PROPOSED SITE PLAN

13925 E US HIGHWAY 24 PEYTON, CO 80831

PARCEL #: 4233001001
AREA: 1,140,836.00 sqft (26.19 acres)

PROPOSED SITE PLAN
13925 E US HIGHWAY 24 PEYTON, CO 80831
PARCEL #: 4233001001
AREA: 1,140,836.00 sqft (26.19 acres)

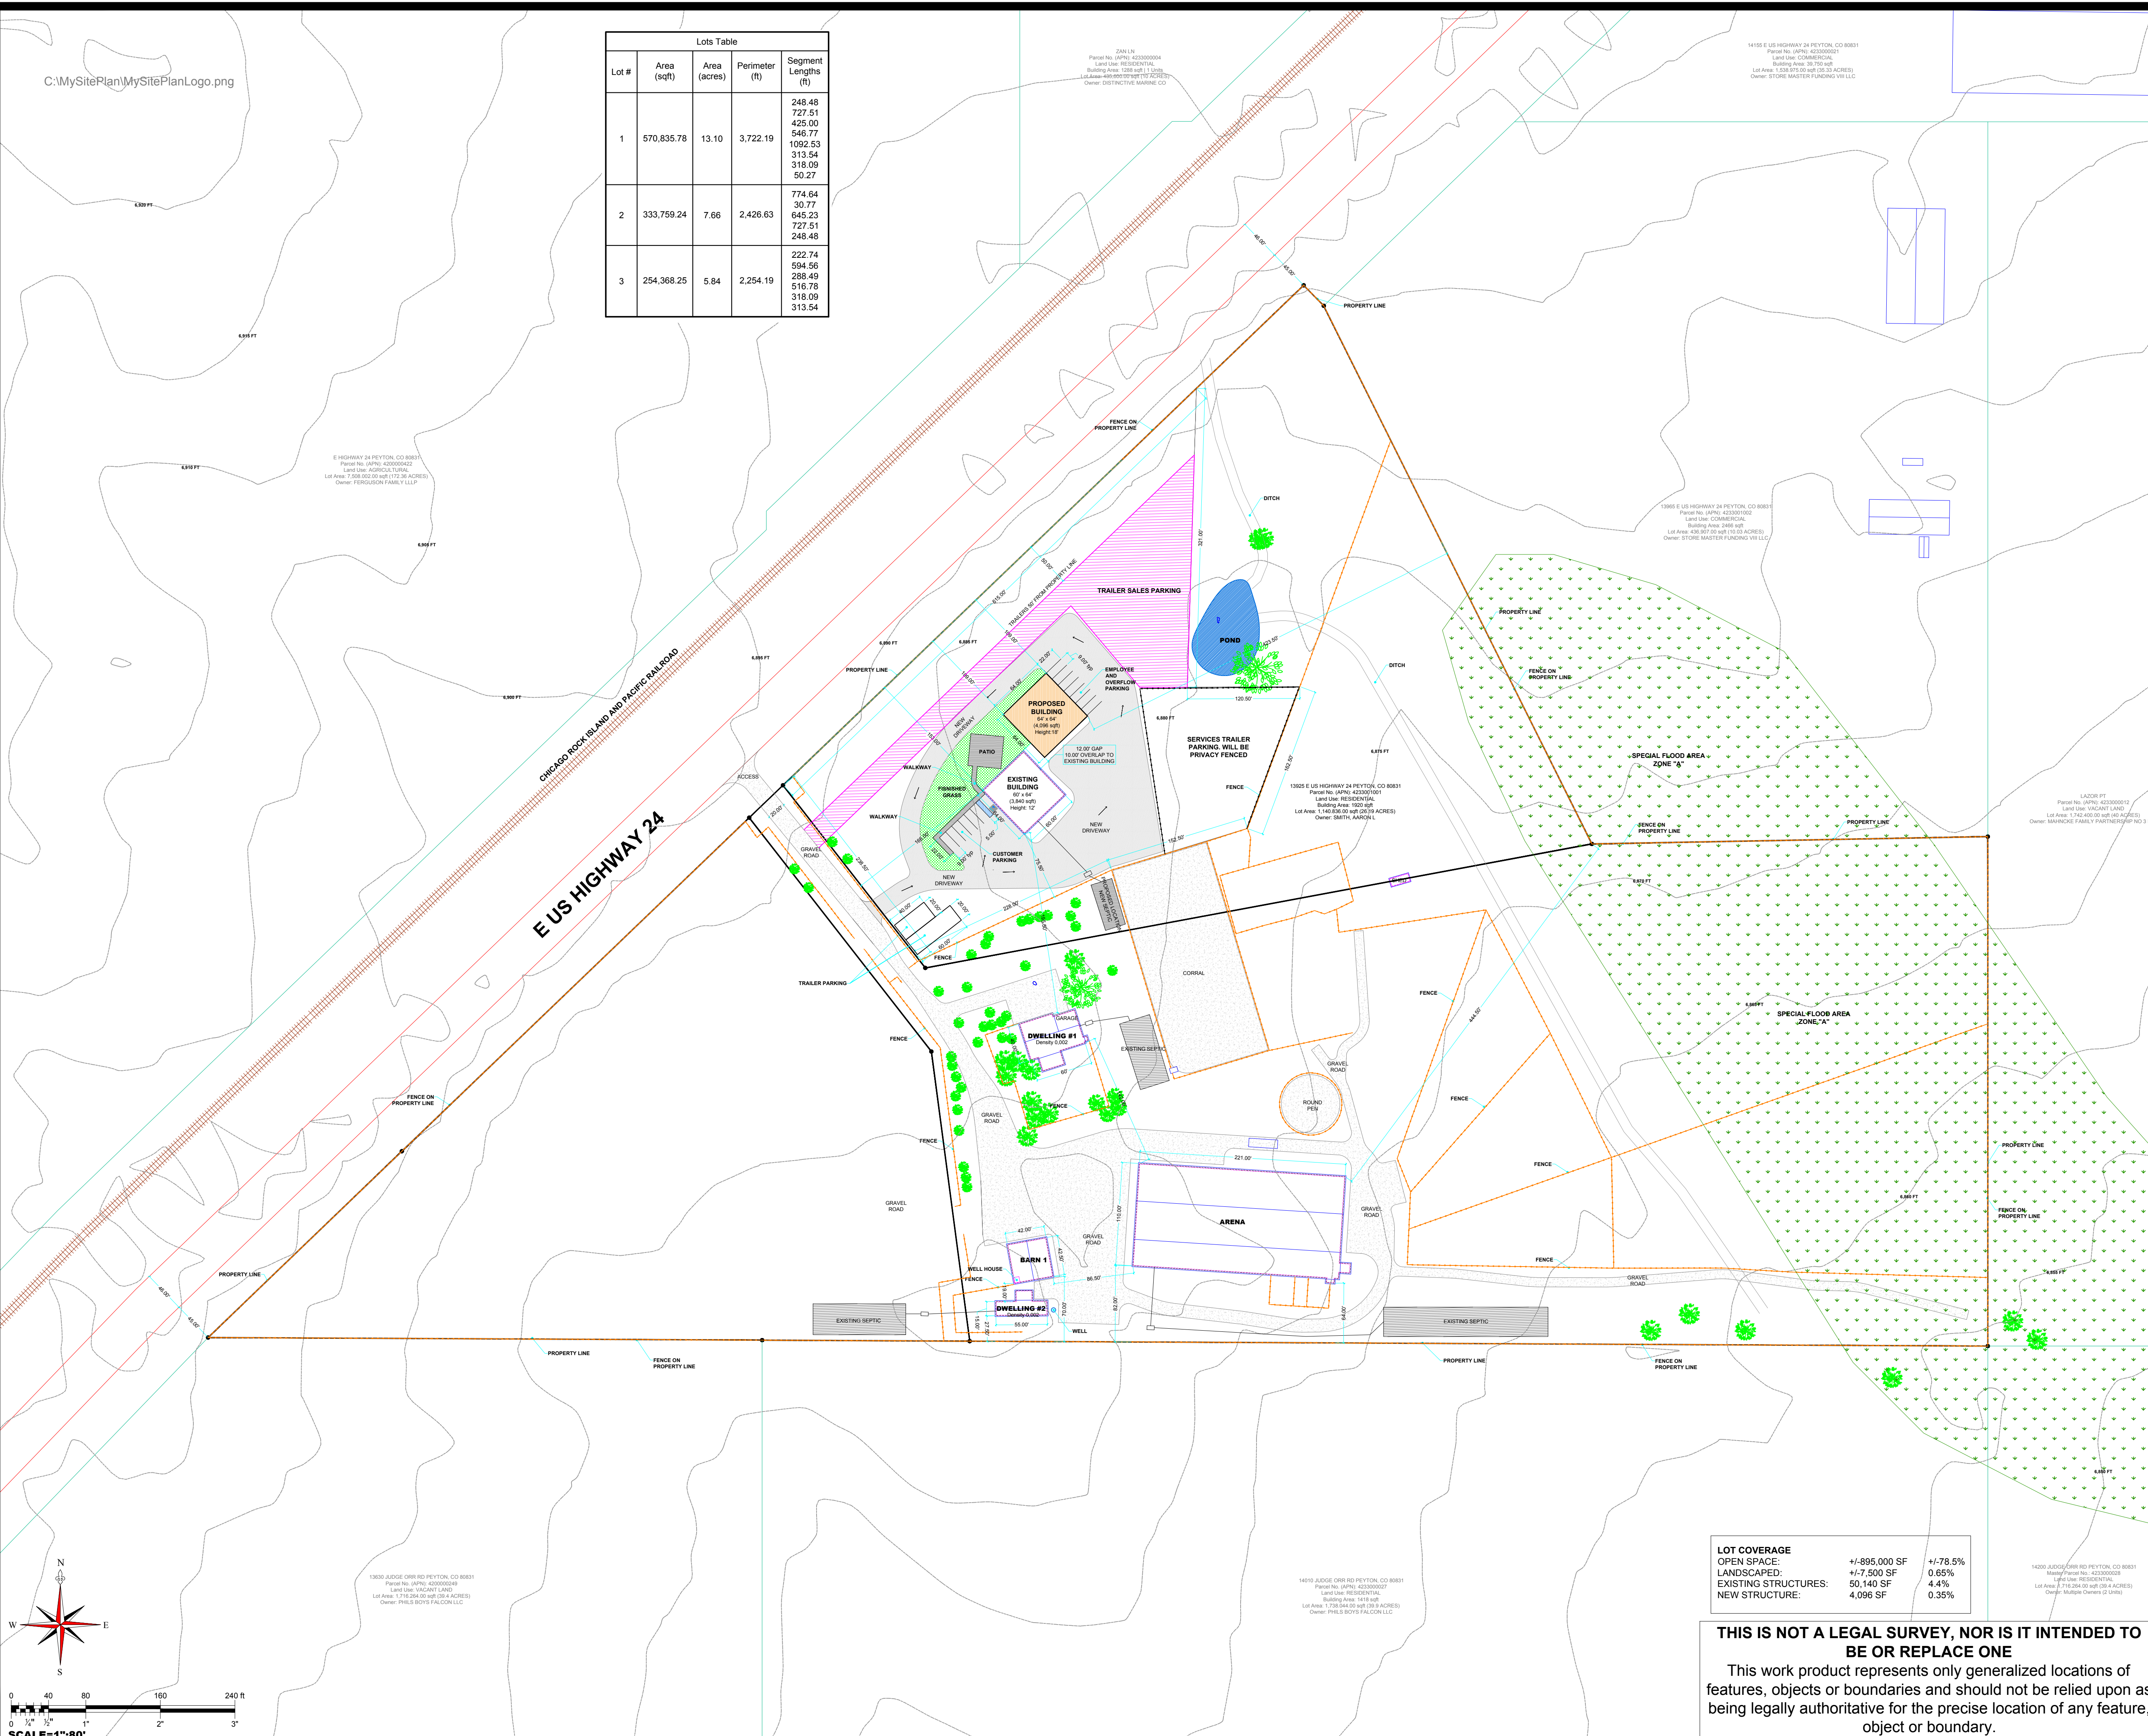
- Version 1 unresolved comments:
Please include:
- Location and dimensions of all existing and proposed signage
 - Location of all no-build areas, floodplain(s), and drainage facilities
 - The location of all ADA parking spaces, ramps, pathways, and signs
 - Standard details of parking (compact, ADA, standard), ADA ramps, driveways, and signs
 - Computation identifying the required parking and the provided parking
 - Location and screening of all dumpsters and loading dock areas

Can this shed be move so it is not on a property line, thus within setbacks?

Setbacks?

The following note should be added to all site development plans or non-residential site plans, as applicable, prior to PCD approval:
The parties responsible for this plan have familiarized themselves with all current accessibility criteria and specifications and the proposed plan reflects all site elements required by the applicable ADA design standards and guidelines as published by the United States Department of Justice. Approval of this plan by El Paso County does not assure compliance with the ADA or any regulations or guidelines enacted or promulgated under or with respect to such laws.
